ENG-CDR21014-R4-CDs.pdf Markup Summary

Subject: Callout
Page Index: 4
Date: 7/27/2022 9:39:11 AM
Author: dsdrice
Color: ■
Layer:
Space:
Page Label: [4] 4 EXISTING CONDITIONS

Subject: Callout
Page Index: 7
Date: 7/27/2022 9:43:27 AM
Author: dsdrice
Color: ■
Layer:
Space:
Page Label: [7] 7 CHANNEL NORTH - PLAN & PROFILE

**C4.0**  
 Sheet 6 of 21

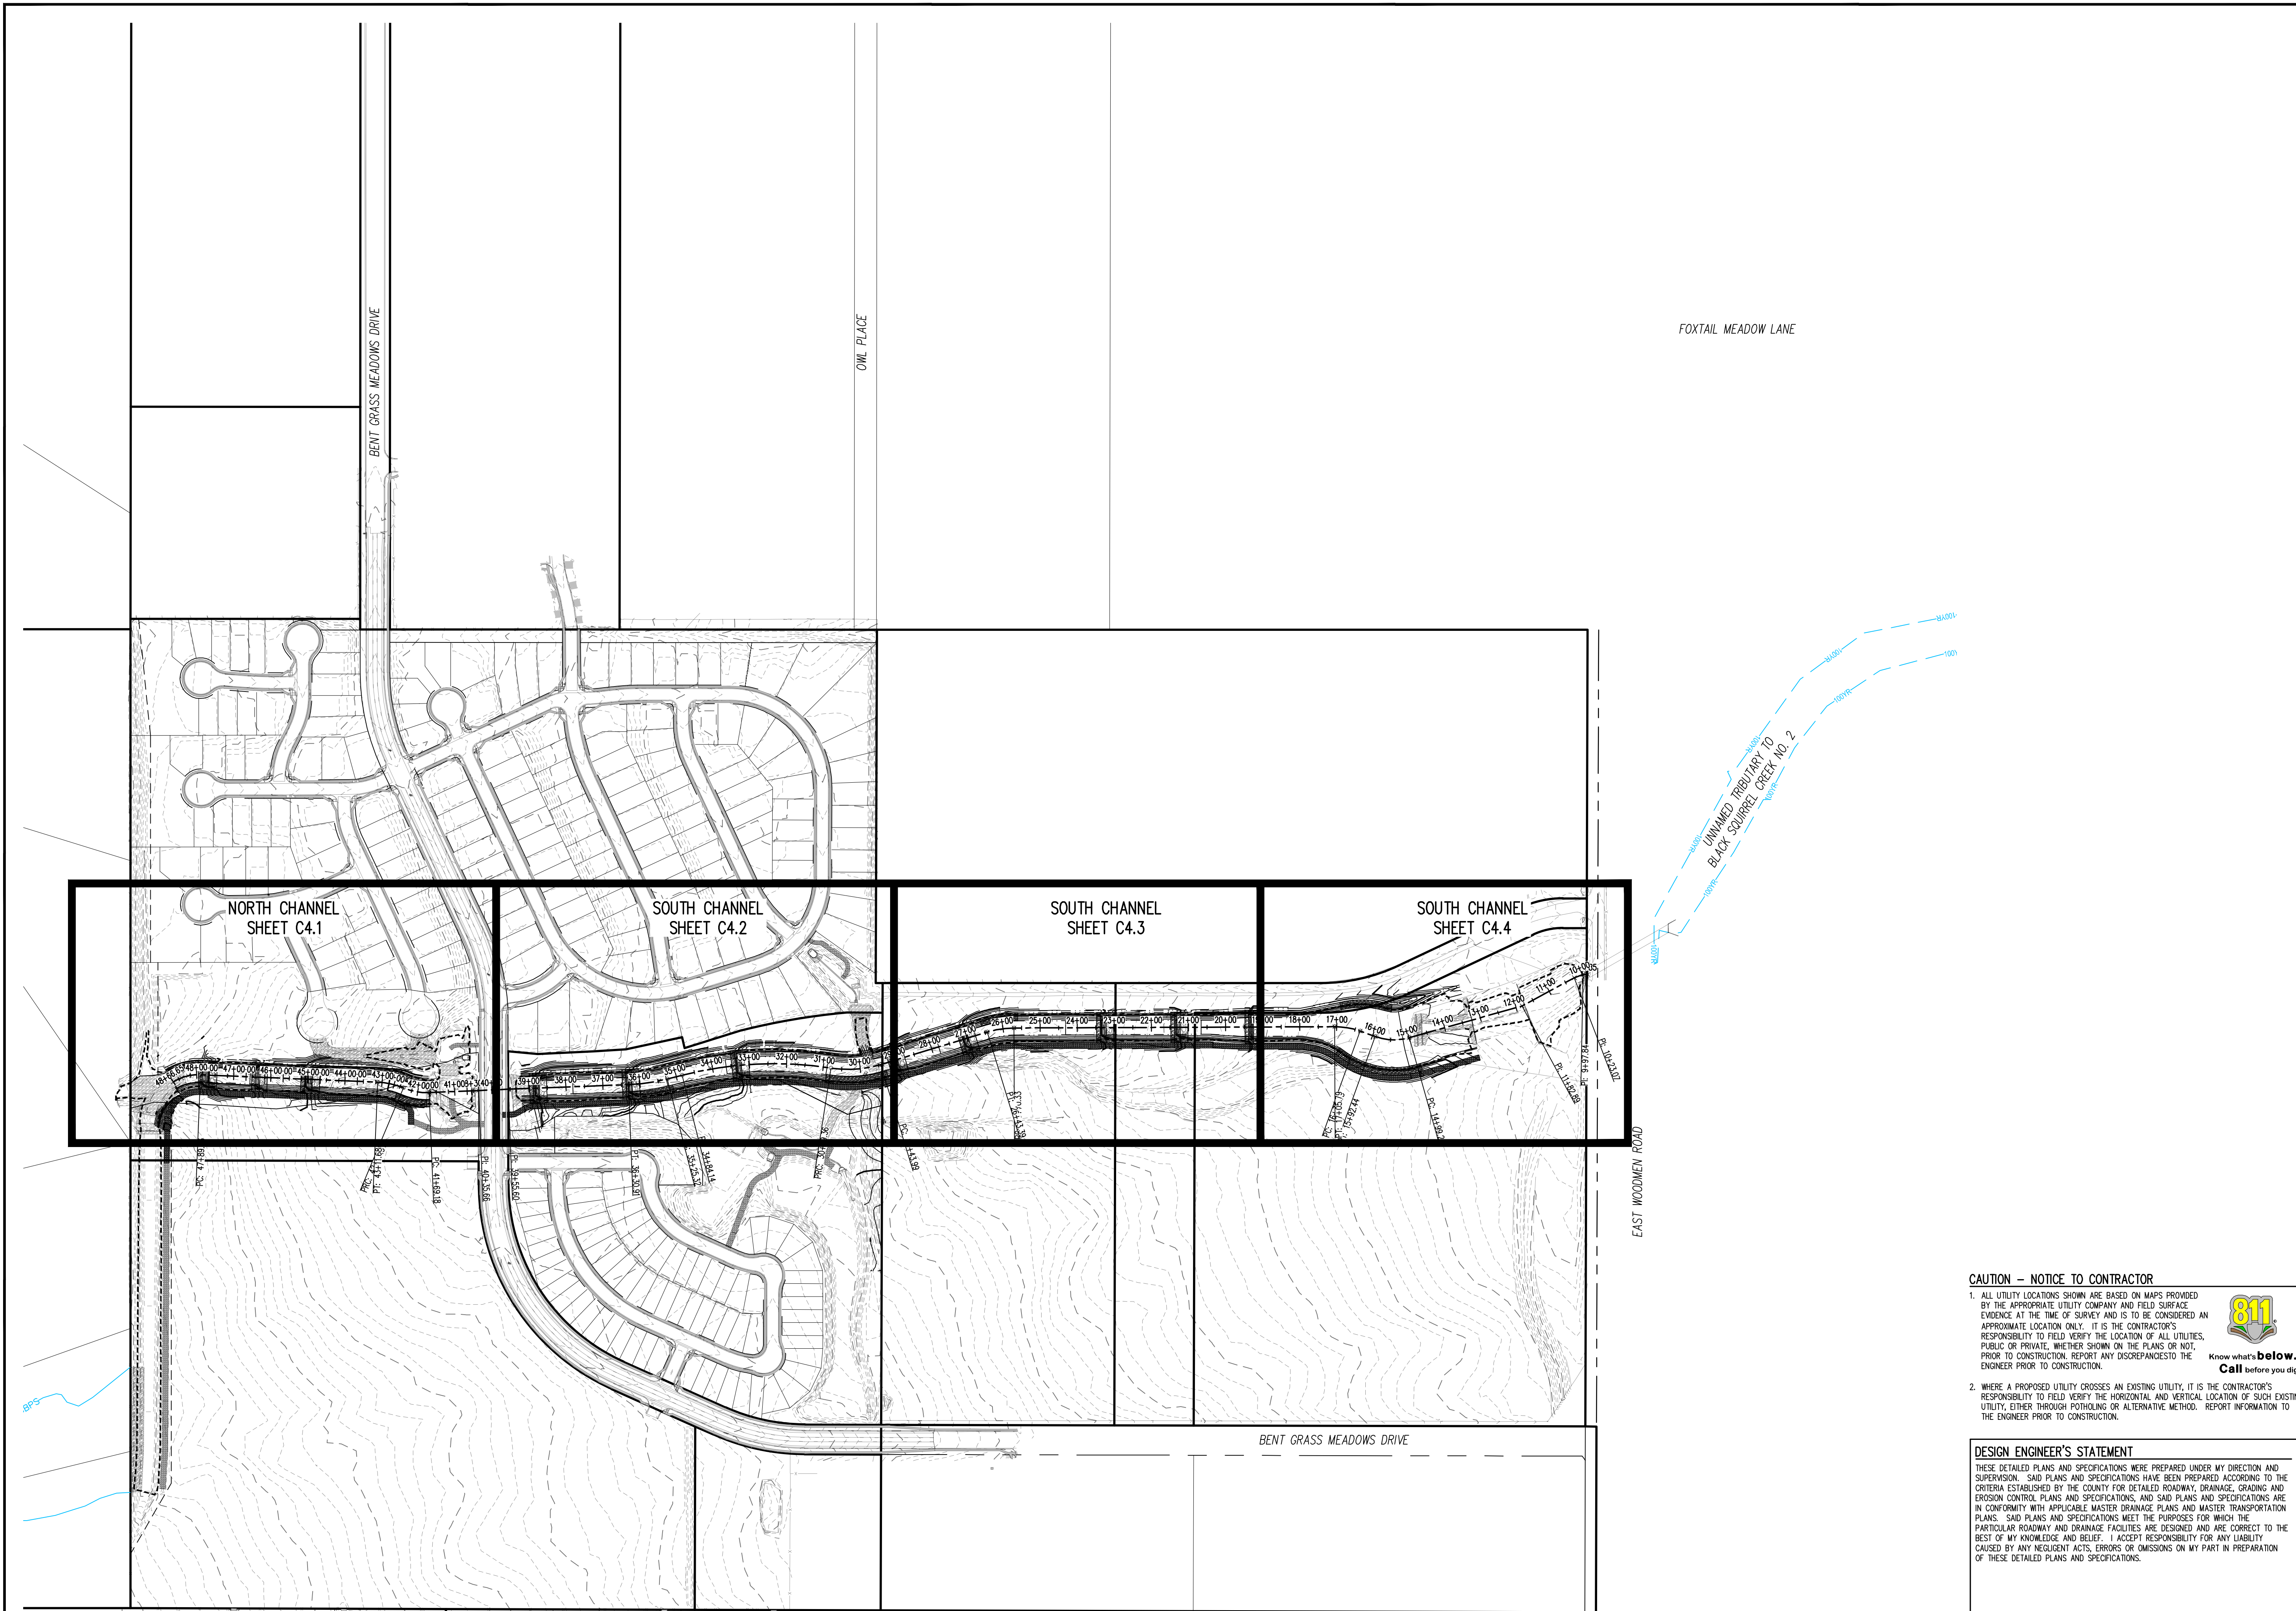
Label slope, elevations, provide cutoff wall and erosion protection for the low-flow channel

Label side slopes (4:1?) and bench grades

Address low-flow channel stabilization on the cross-section and GEC Plan. Reference UDFCD 8.5.6 and Figure 8-18 for examples.
